## KITTITAS COUNTY COMMUNITY DEVELOPMENT SERVICES

RE: Burbank Creek LLC Segregation, SEG-08-00035

## MEMORANDUM

TO: Community Development Services  
FROM: Christina Wollman, Planner II *CW*  
DATE: November 24, 2008  
SUBJECT: Burbank Creek LLC SG-08-35. 15-19-14050-0002, -0003. 15-19-13050-0005.

# RECORD OF SURVEY FOR ADMINISTRATIVE SEGREGATION

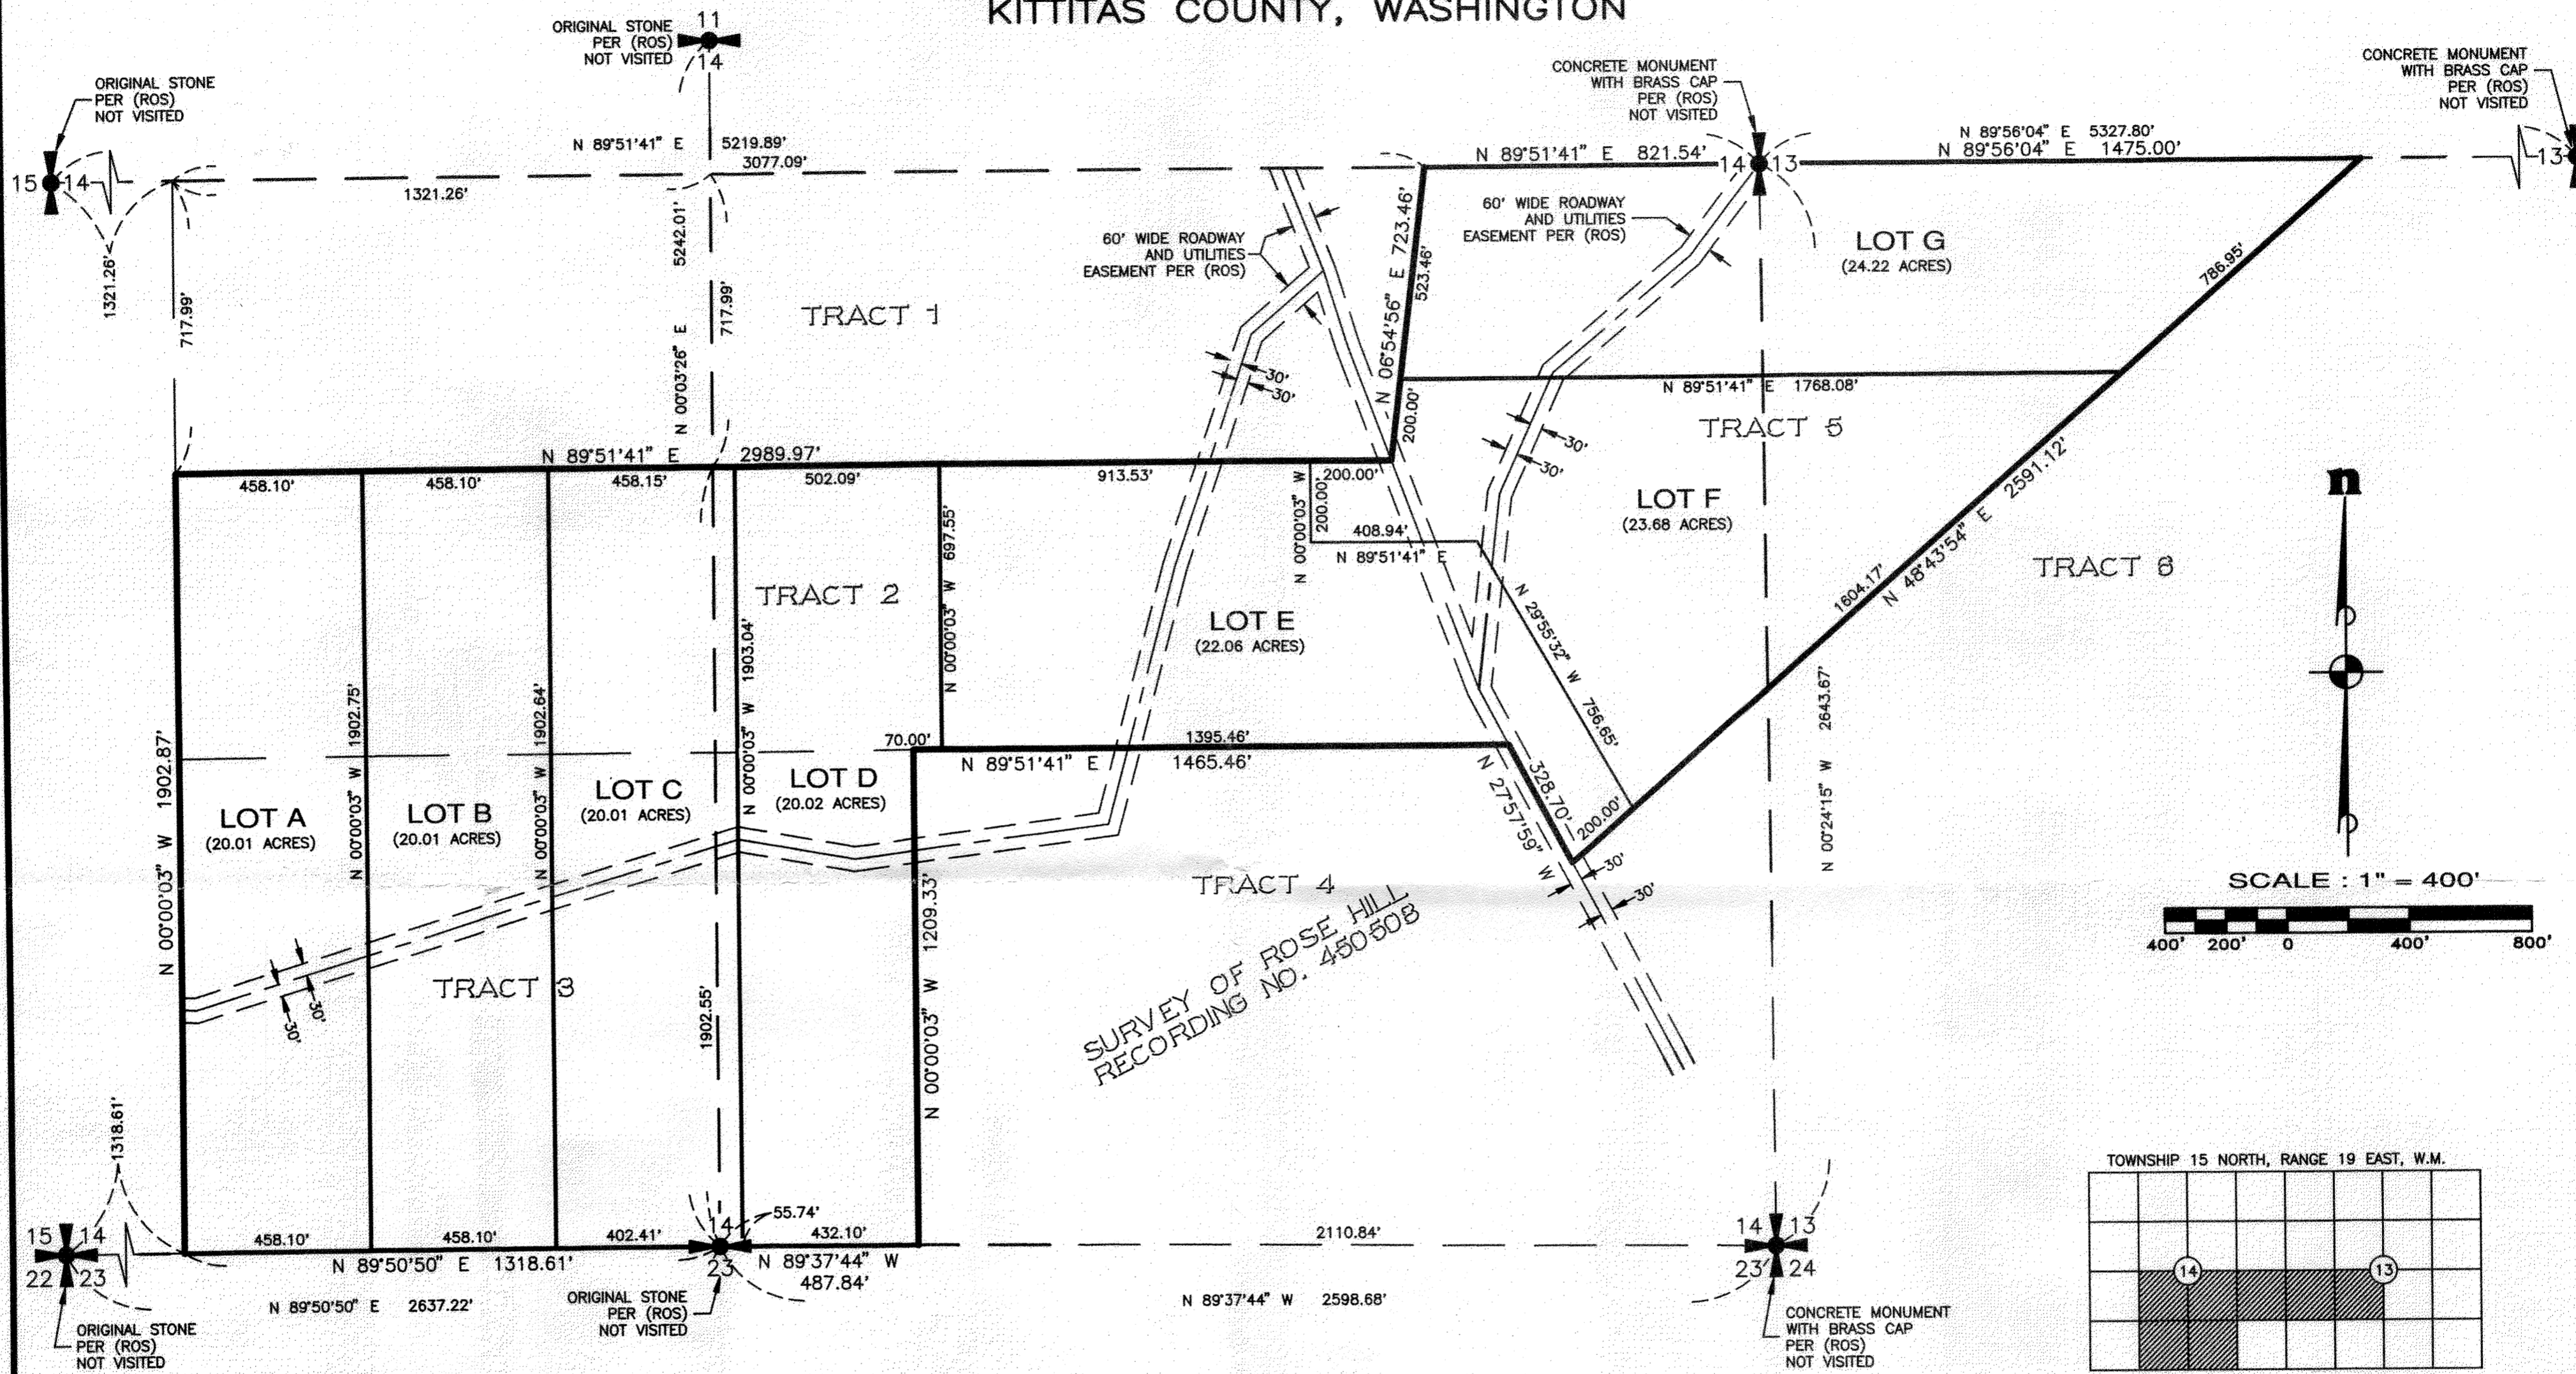
1. Burbank Creek Road serves more than 40 lots and a second access to SR 821 will be required. Both Burbank Creek Road and the second access shall be constructed to meet or exceed Low Density Private Road requirements. Additional information showing the route of each access shall be submitted to Public Works.
2. Road names and AFNs shall be shown on the final survey.
